DA NO: 25-2017-2-1

PROPOSAL: Brandy Hill Quarry Expansion (SSD 5899)

PROPERTY: Clarence Town Road, Seaham NSW 2324

Council has completed a review of the RTS and provides the following advice.

**Figure 1:** Transport routes and locations of bus stops along Clarence Town Road and Brandy Hill Drive

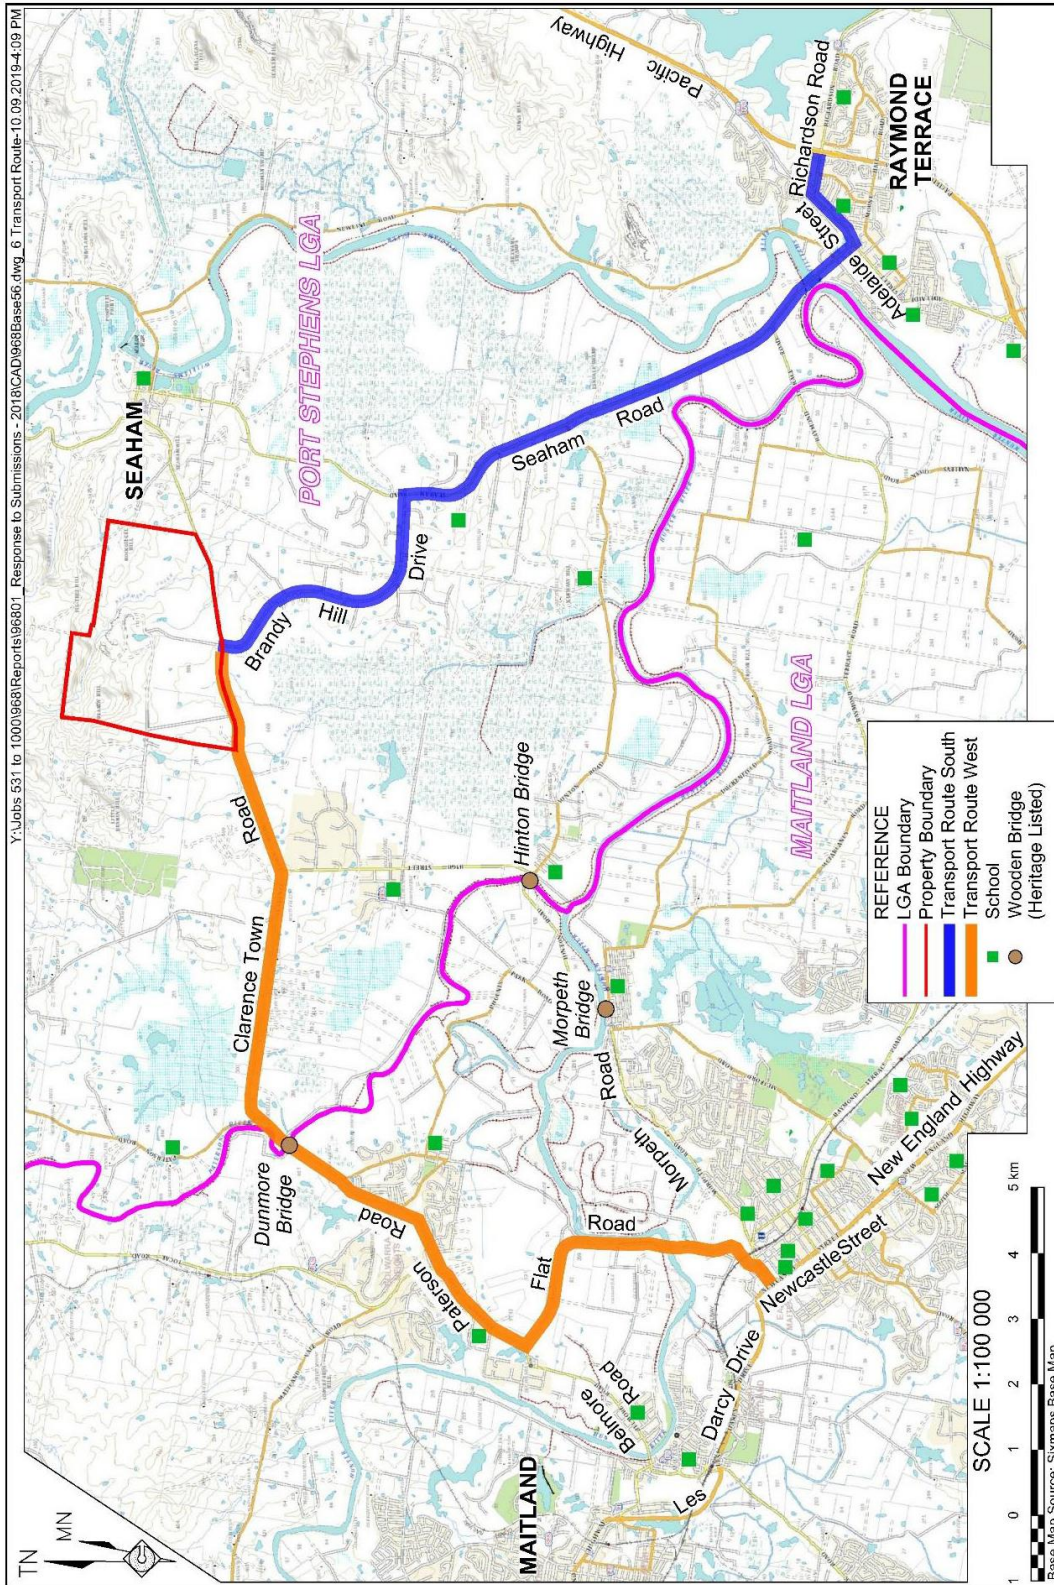
Hanson has advised that it is not practical to limit transport routes. Council's previous submission required Hanson to use only the proposed haulage routes unless they have received prior written permission from Council. This advice has not changed. This is consistent with similar processes for all quarries in the Local Government Area (LGA) and enables Council to direct expenditure to repair roads which are utilised by haulage trucks.

In addition, Council recommends the following change to the proposed major haulage route in order to limit use of local roads as far as possible. Instead of turning right into Adelaide Street, Raymond Terrace Council requests a left turn to be required as it would aid for better traffic flow because there is an interchange and a ramp onto the Pacific Highway further along this route. This would avoid entering the Pacific Highway at a roundabout at Heatherbrae.
